March 11, 2014

Memo To: Barbara Barhydt  
Jean Fraser  
From: David Margolis-Pineo  
Re: 421 Warren Av  
Commercial Site  
PH Warren Avenue, LLC

**BOUNDARY SURVEY**

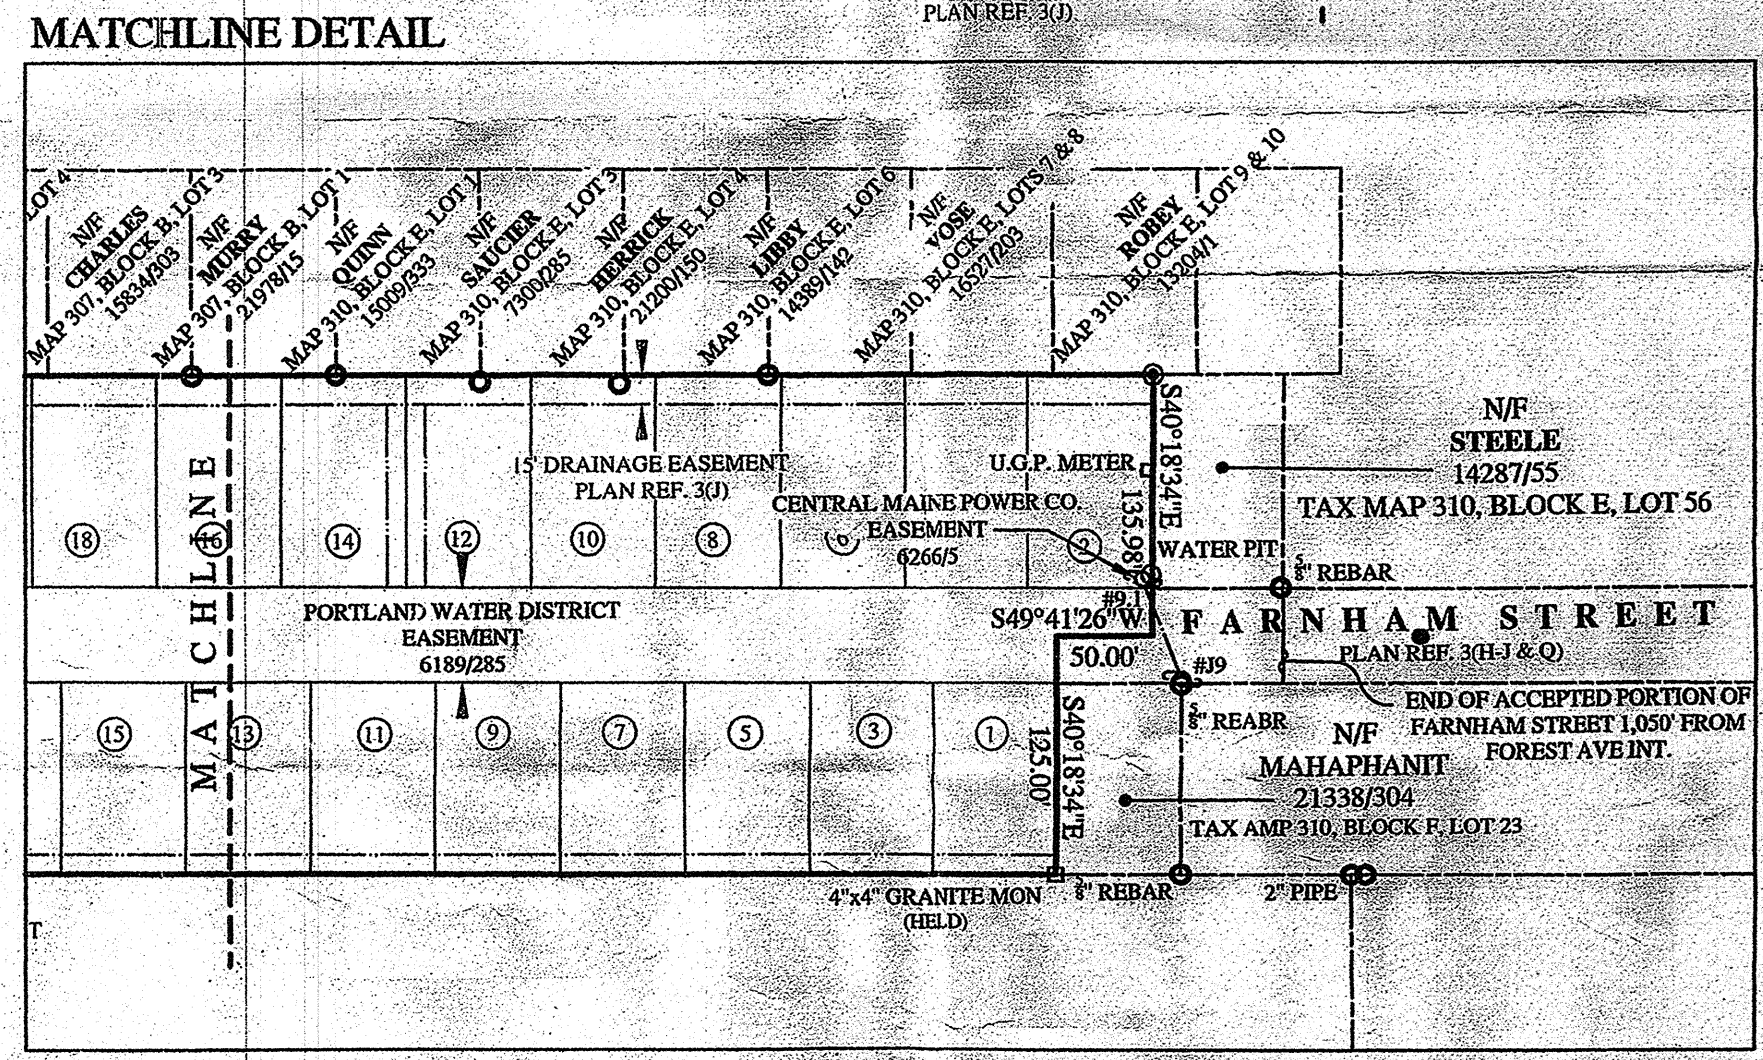
2. It would be desirable for the applicant to tap for the 2" domestic water service behind the sidewalk to avoid cutting into the sidewalk.
3. Please note on survey plan that Saville Street and Newcomb Street are Continued Paper Streets as per City Council Order #84 in September 1997.

4. Please add State Plane Coordinates for four (4) corners; at both ends of the rear 657.94' line and at both ends of the 140.51' line along Warren Ave.

DATE: NOVEMBER 2013
SCALE: 1" = 30'
JOB NO.: SP-M104
FILE NAME: SP-M104-SITE
SHEET C-30

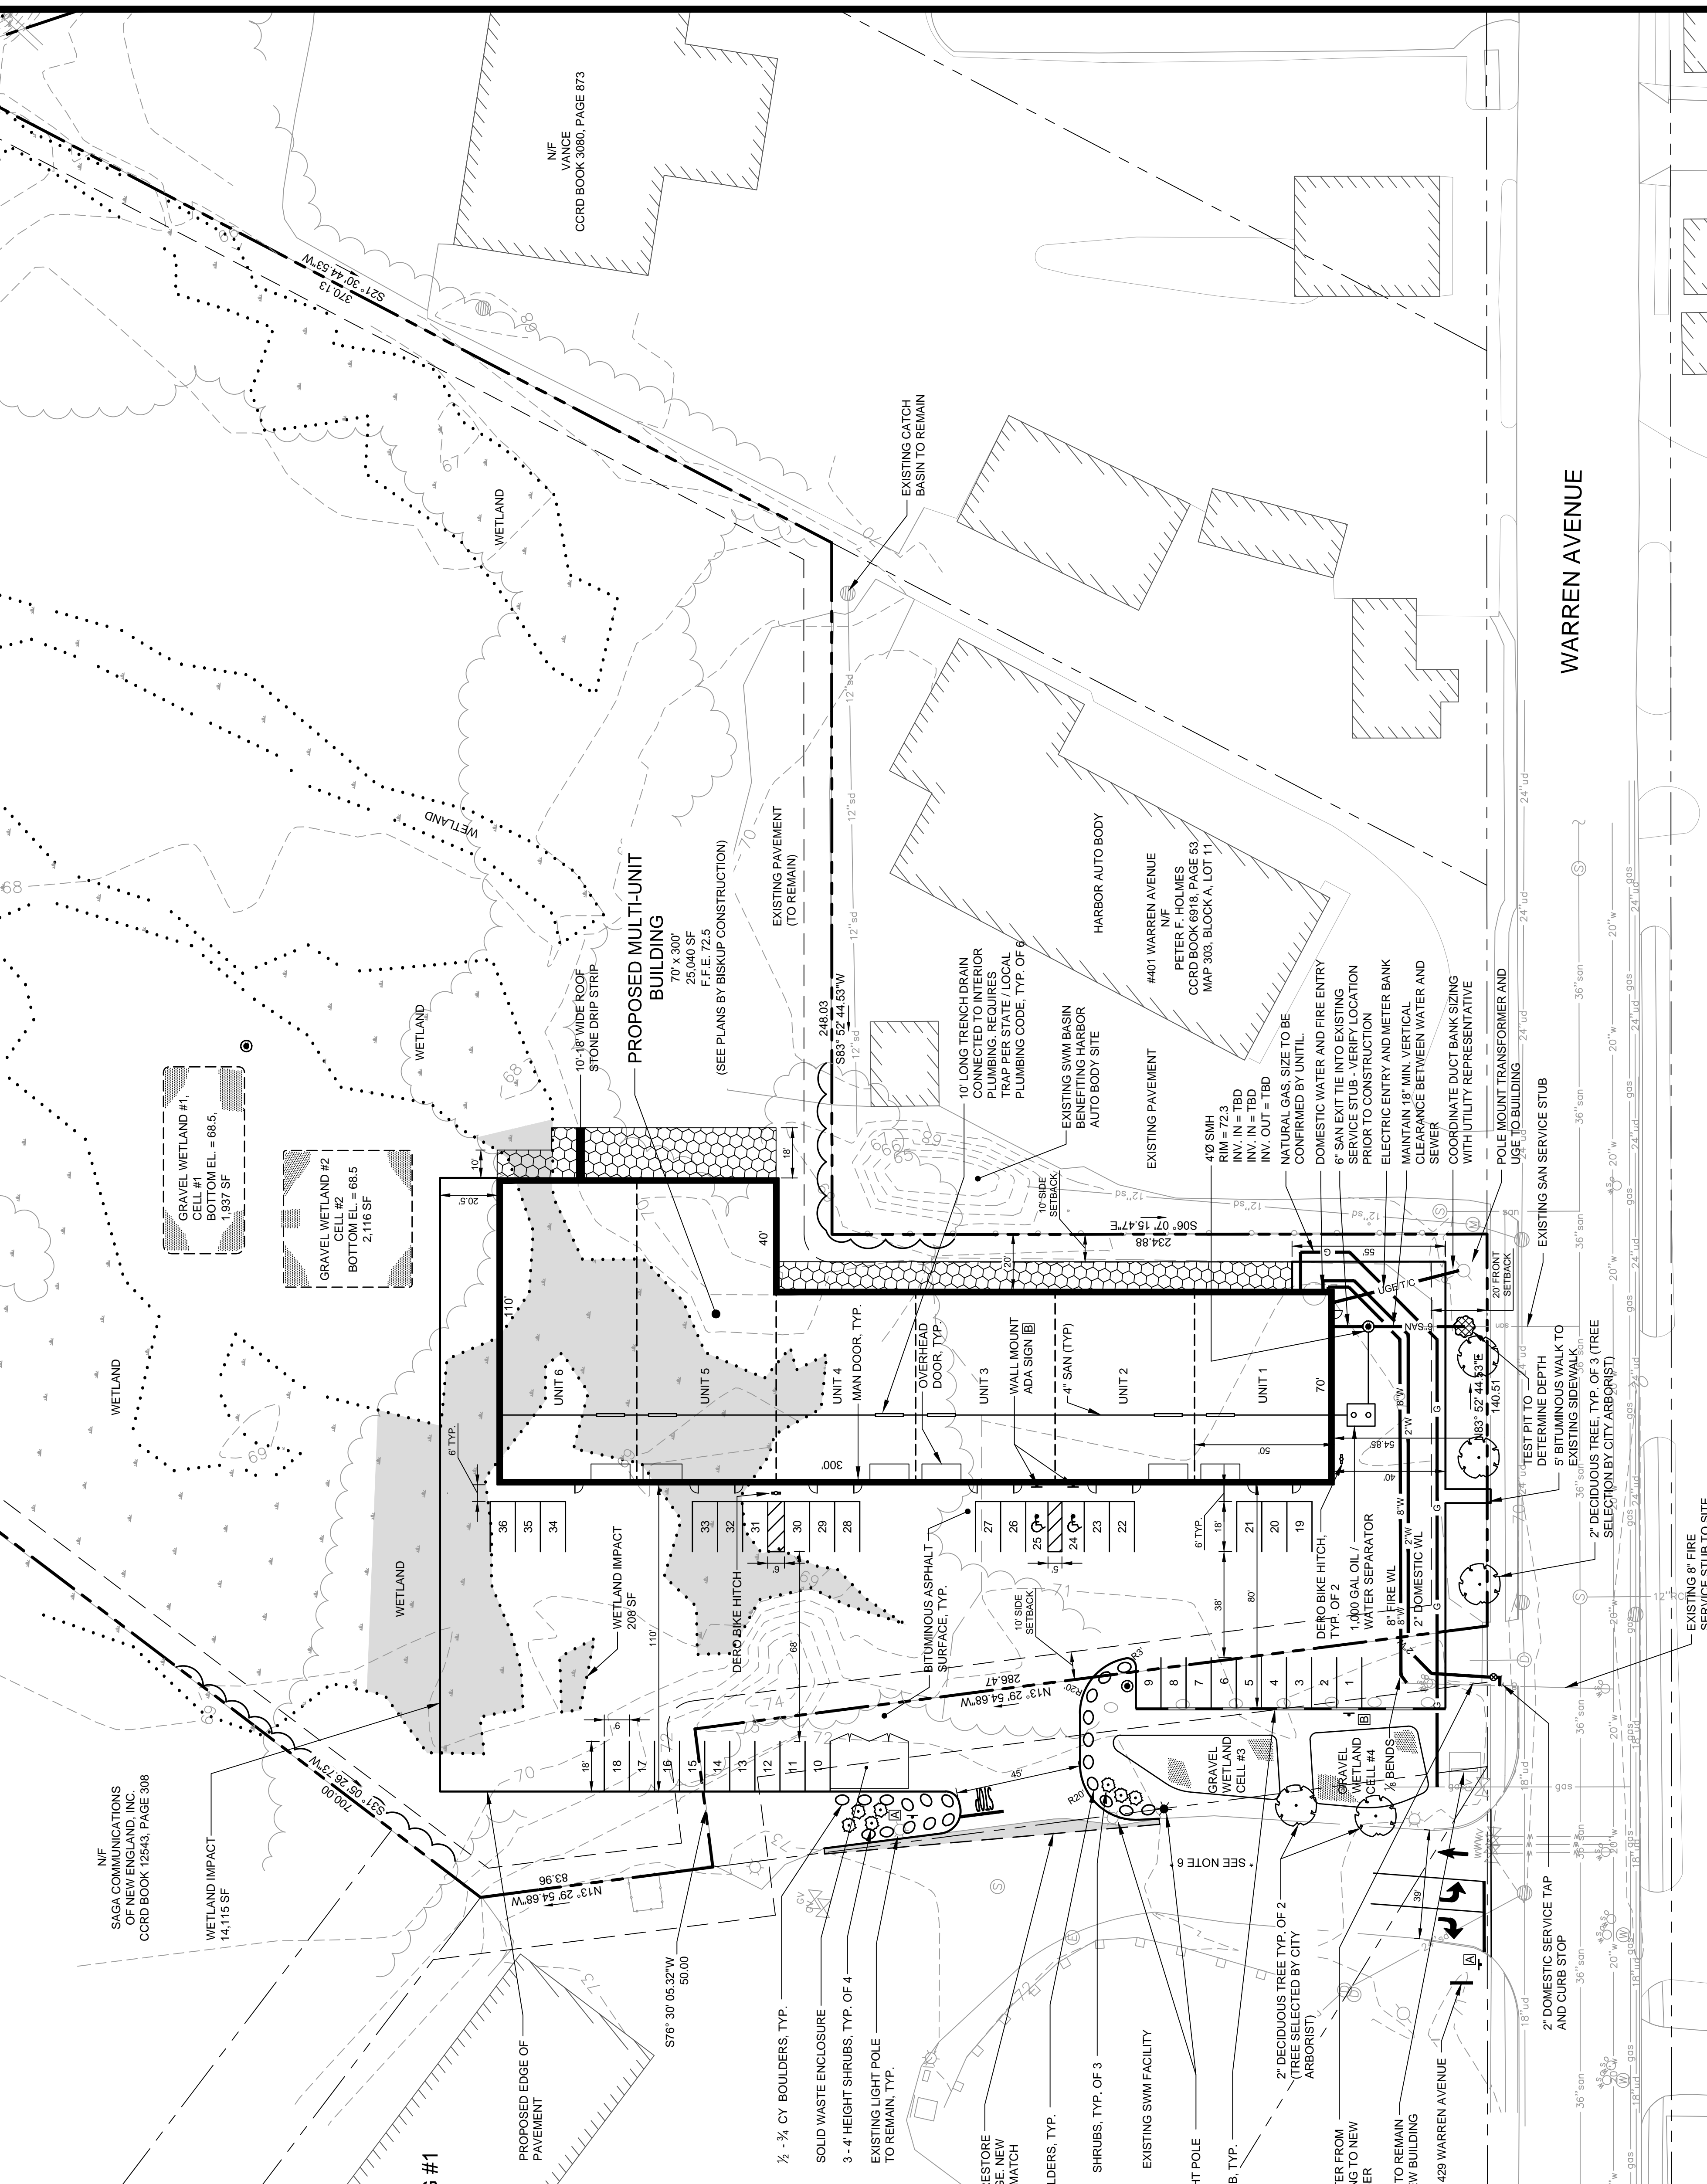
1. Since the curb cut on Warren Ave in front of this project is not proposed to be used, the applicant is requested to close the curb cut. The curbing shall be set in concrete to match the abutting curb work. Please contact Rhonda Zazzara for details. 874-8831  
Warren Ave in this area is currently under a pavement moratorium until October 26, 2014. However as long as the applicant does not encroach the pavement more than two feet from the face of curb, no moratorium repair will be requested if the work is done before this date. A Street Opening Permit will be required.
